Sent: 30 September 2013 10:39
To: Planning
Subject: ✓ Planning application S6/2013/1469/FP - Oak Cottage Residential Home, 4 Wilkins Green Lane

District ref: S6/2013/1469/FP
HCC ref: WH/276/2013 (Amended)
HCC received: 27/09/2013
Area manager: James Dale
Case officer: Lindsey Lucas

Oak Cottage Residential Home, 4 Wilkins Green Lane
Hatfield

Erection of single storey side and rear extension and two storey rear and side extensions.

TITLE Proposed Ground & First Floor Plan		
PROJECT NAME Oak Cottage, 4 Wilkins Green Lane, Hatfield, AL10 9RT		
DRAWN BY E.B	DATE SEPT 2013	
SCALE 1:100 @ A1	CHECKED	
DRAWING NO. EL/2012/05	REV. NO. E

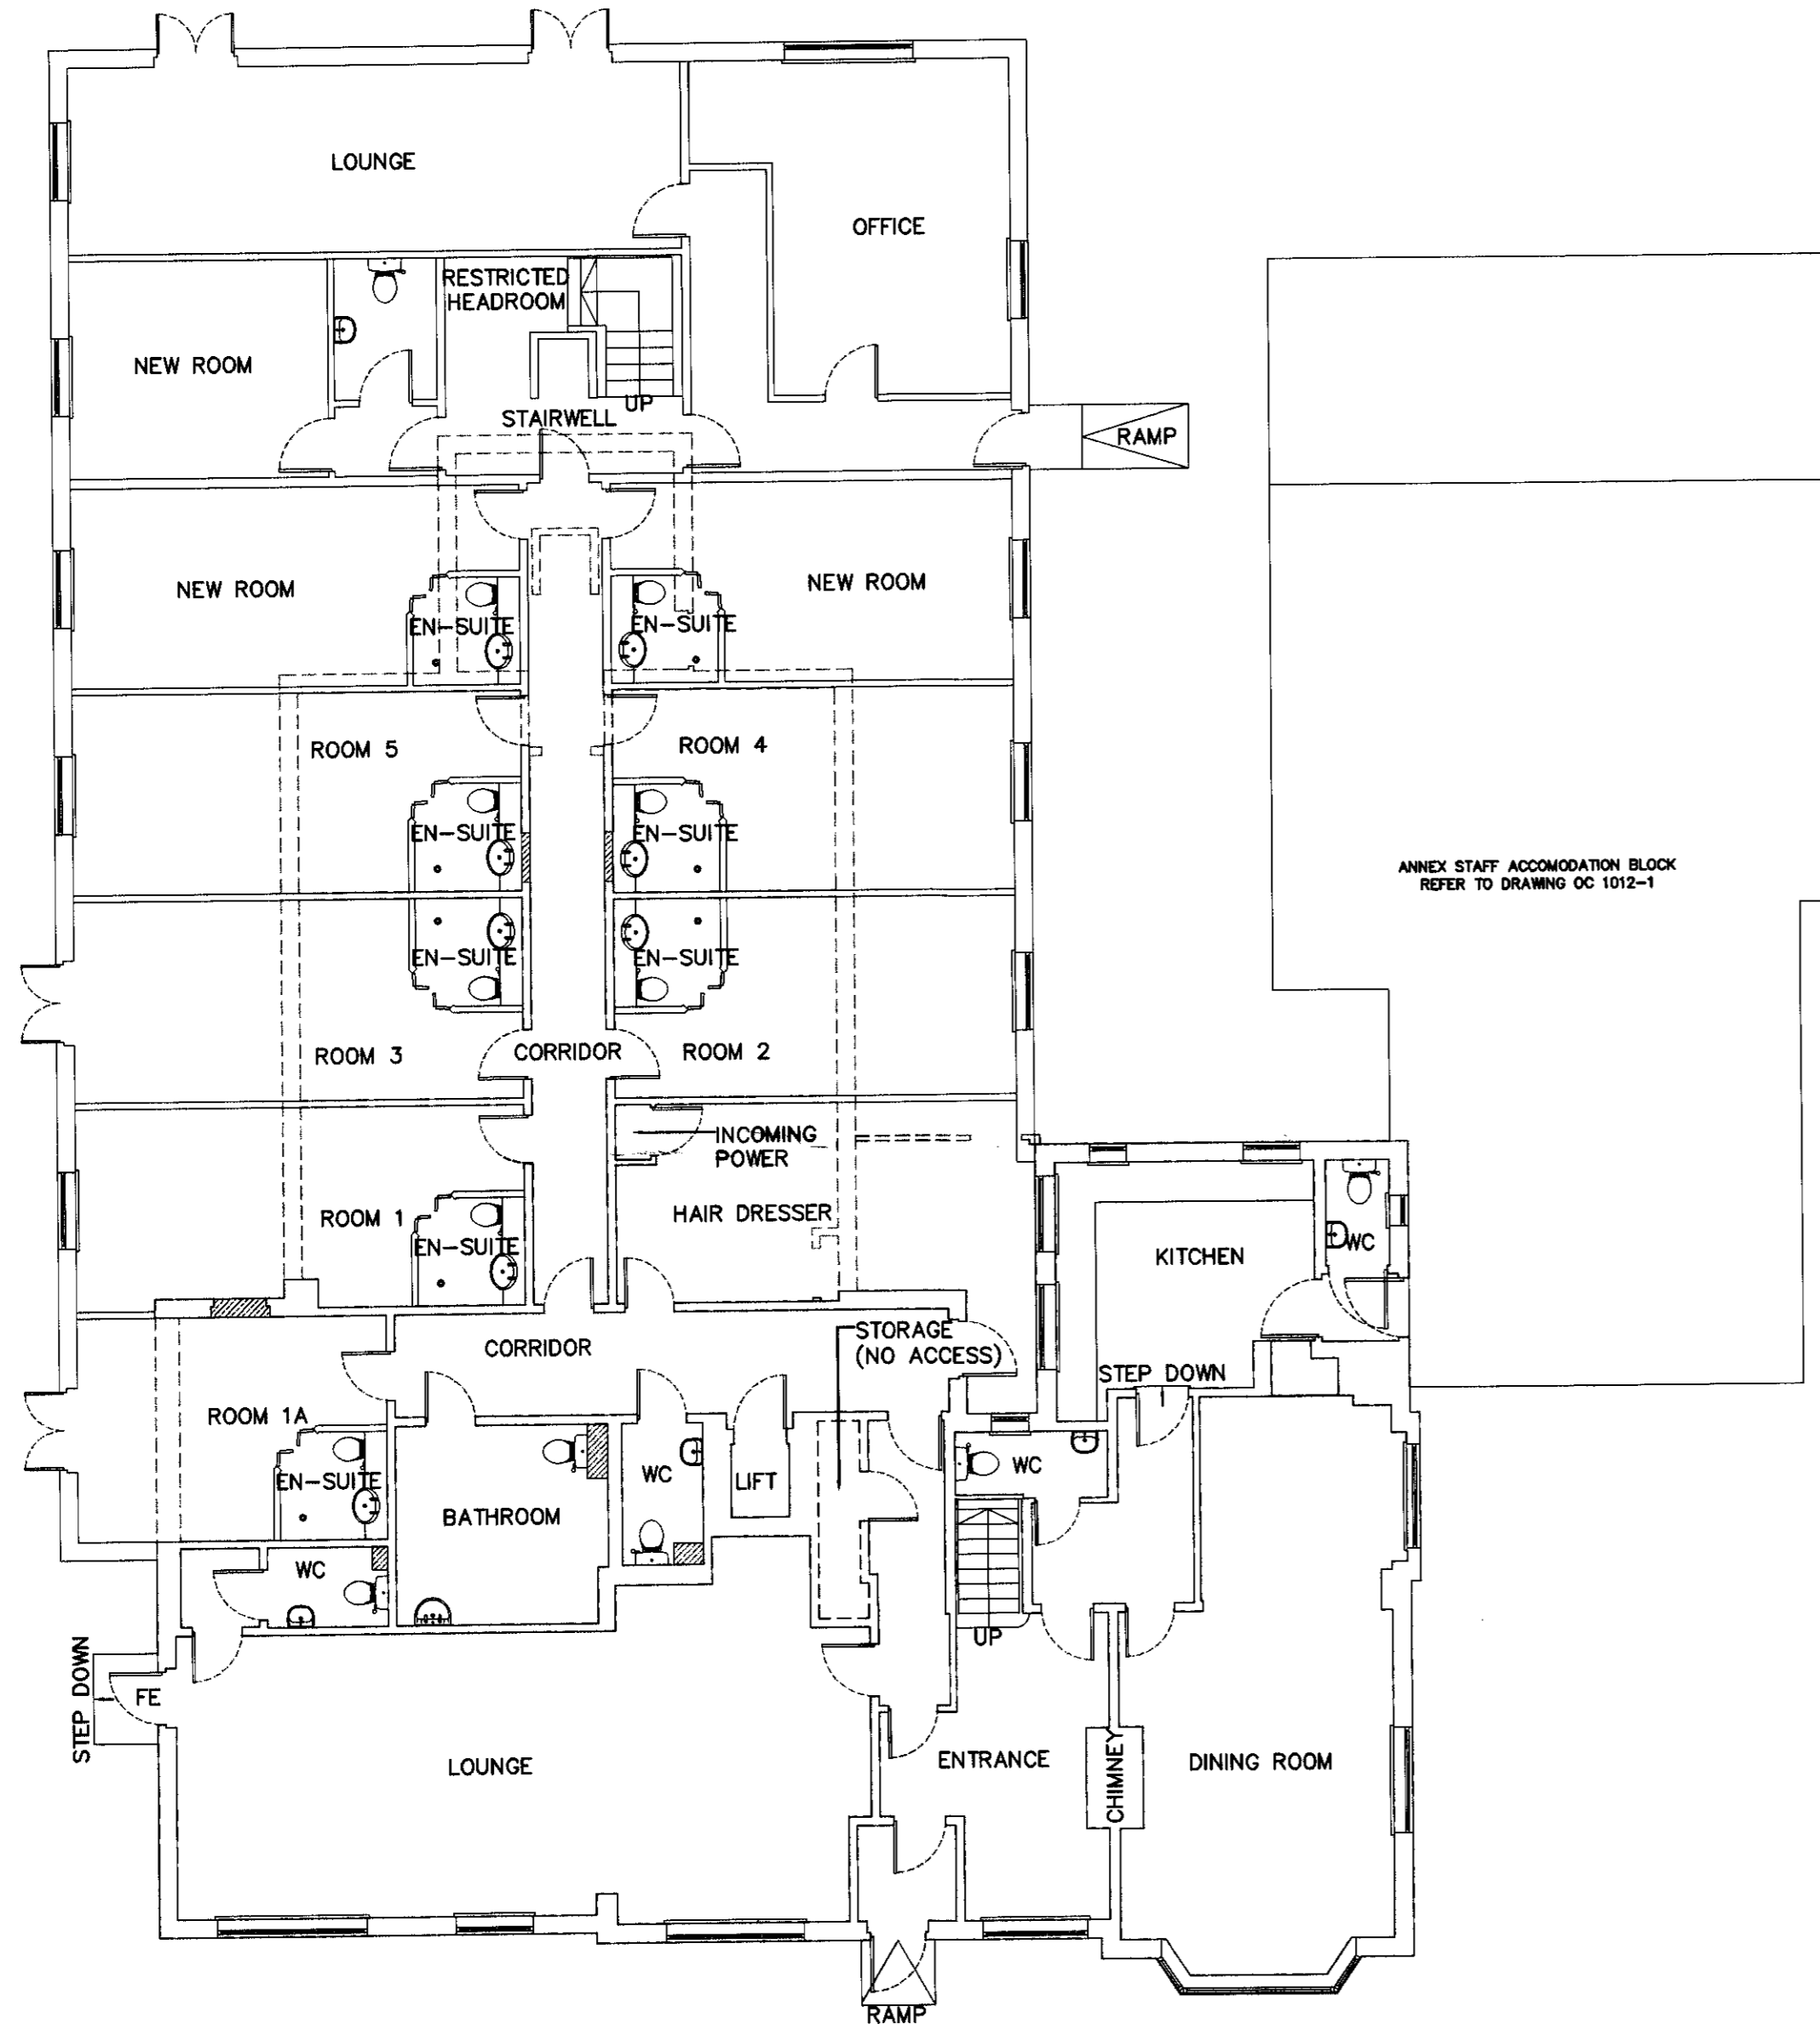
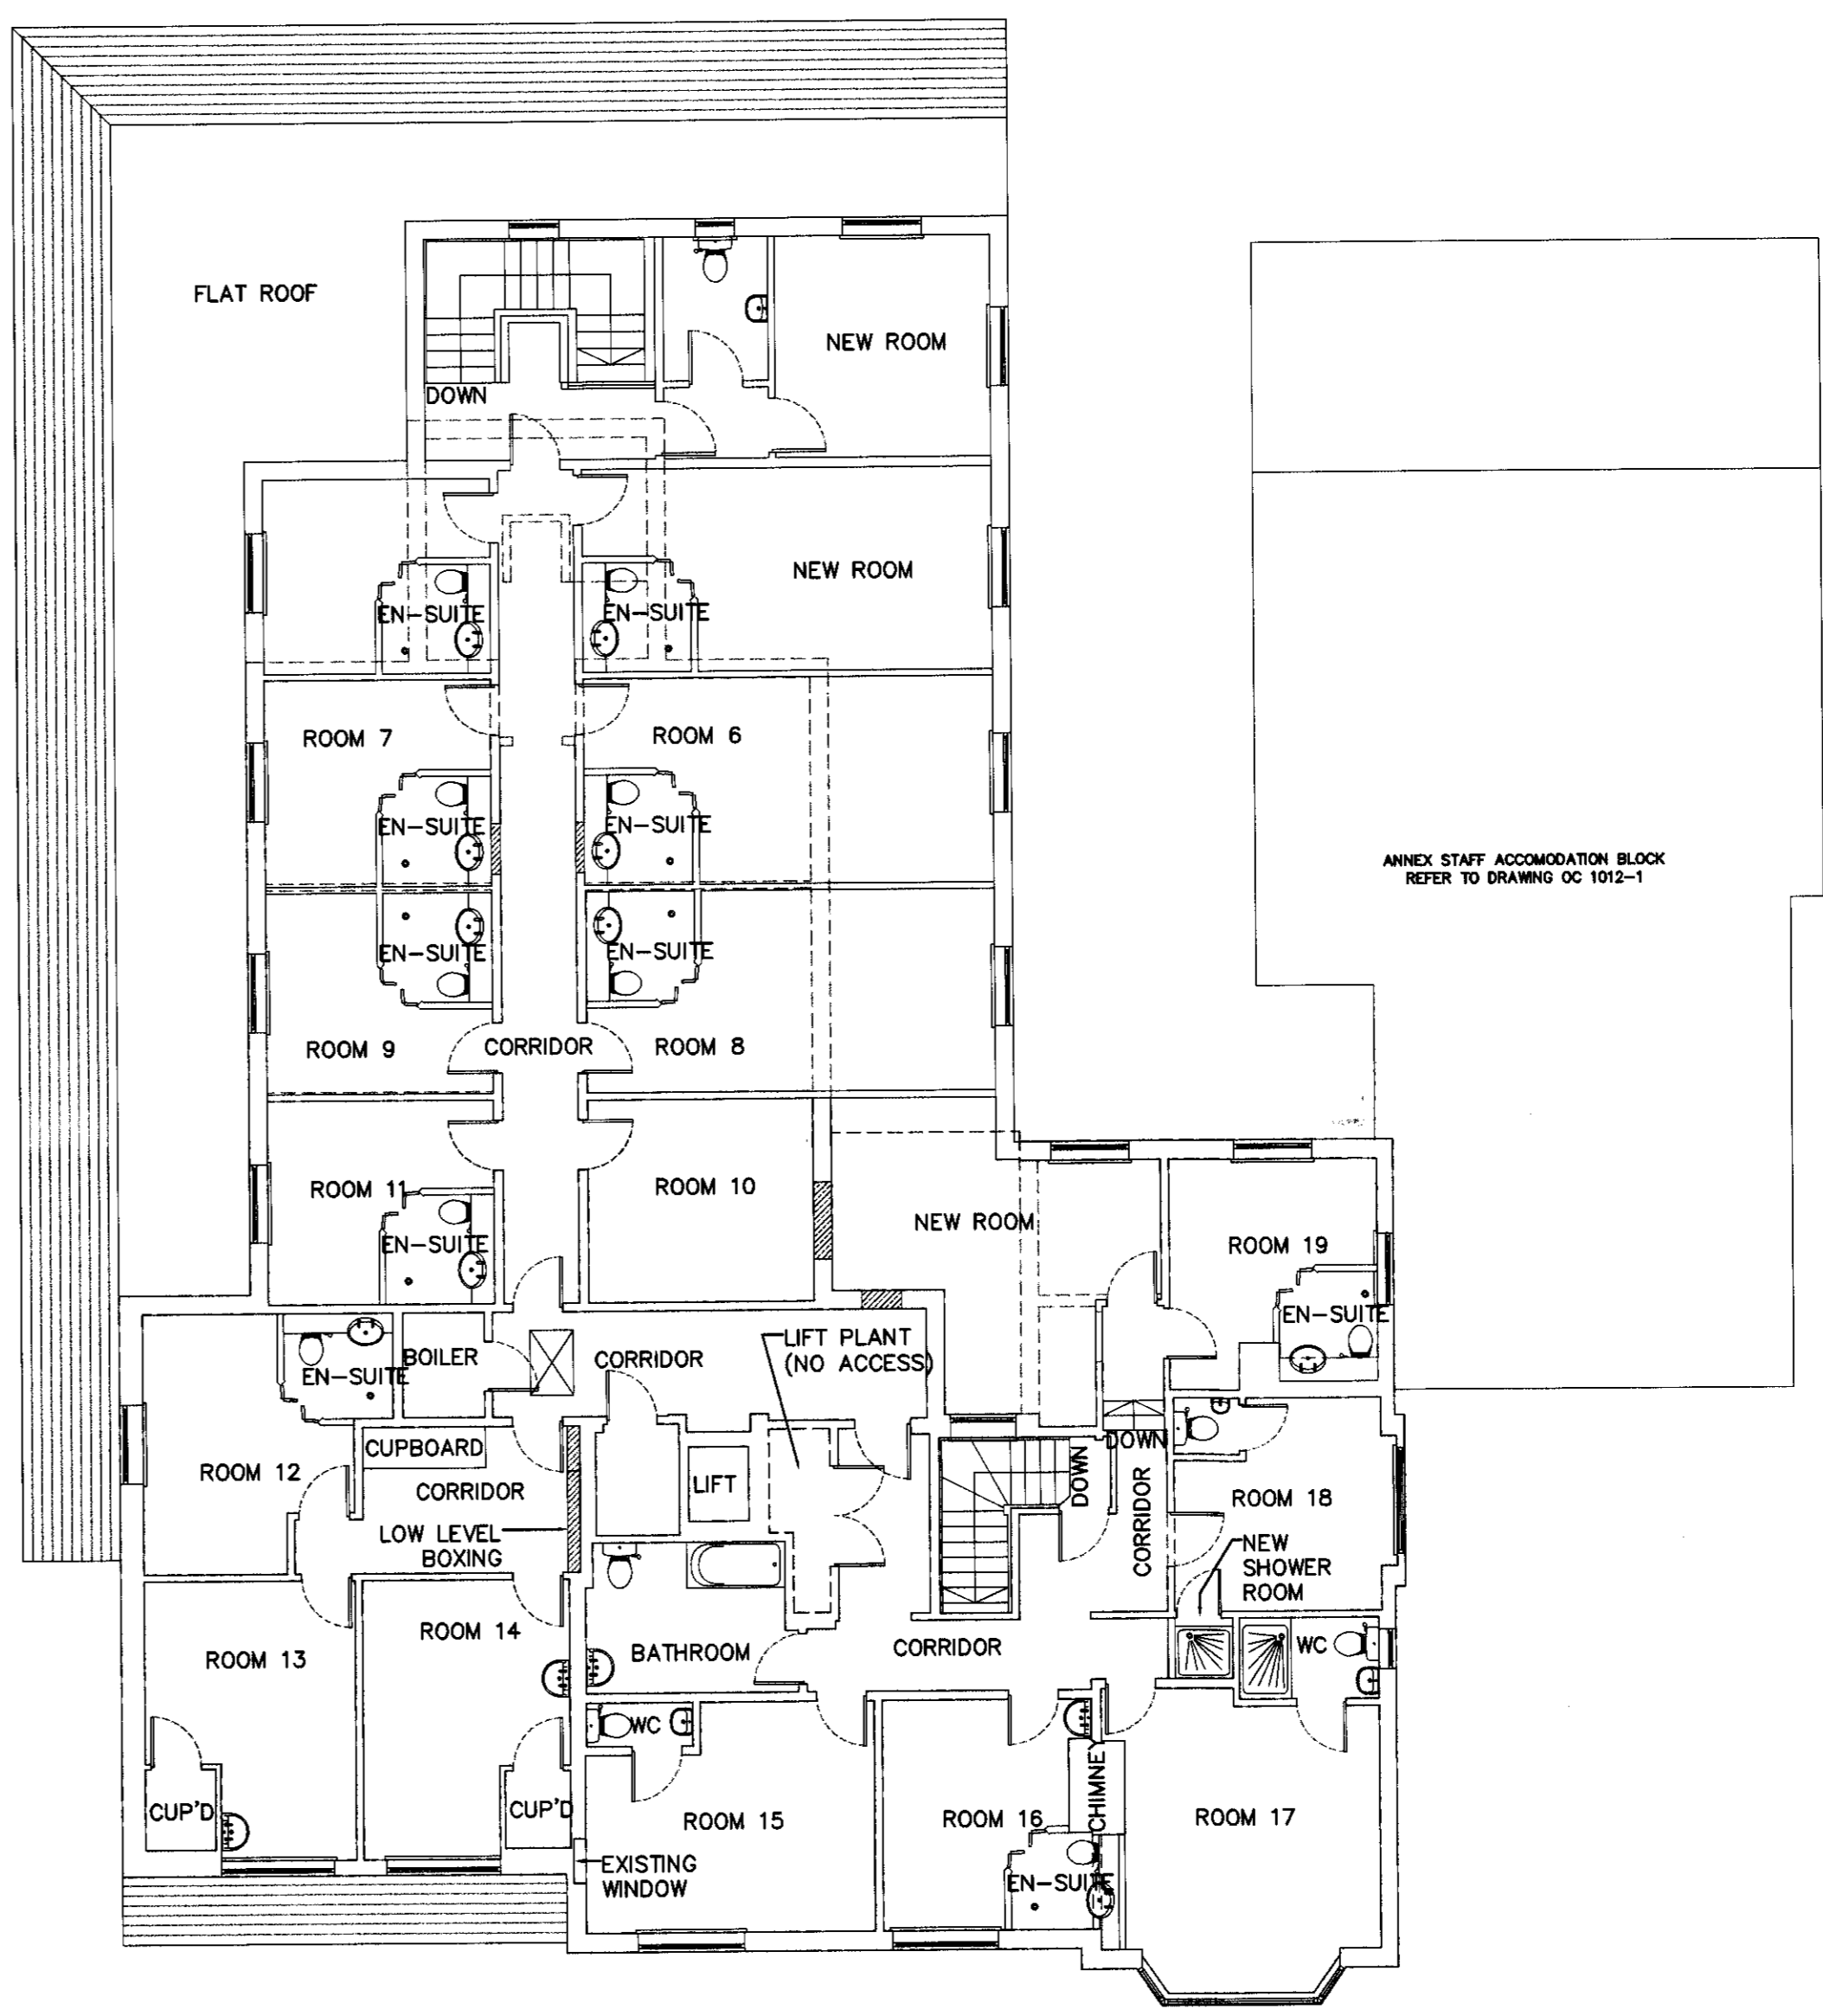
These amendments show the inclusion of a staff accommodation annex, however this building already appears to exist and I assume that staff numbers are as given on the application form. As such the amended drawings do not alter the previous comments of the Highway Authority.

Although different numbers are given on the application form, the drawings show an increase in the number of rooms from 20 to 26. The Design and Access statement indicates that on site parking will be increased from 10 to 16 spaces. The proposed parking plan shows that all vehicles will be able to enter and leave the site in a forward gear.

1. Prior to first occupation of the development the associated car parking shown on approved plan labelled proposed parking plan shall be laid out and used for no other purposes.
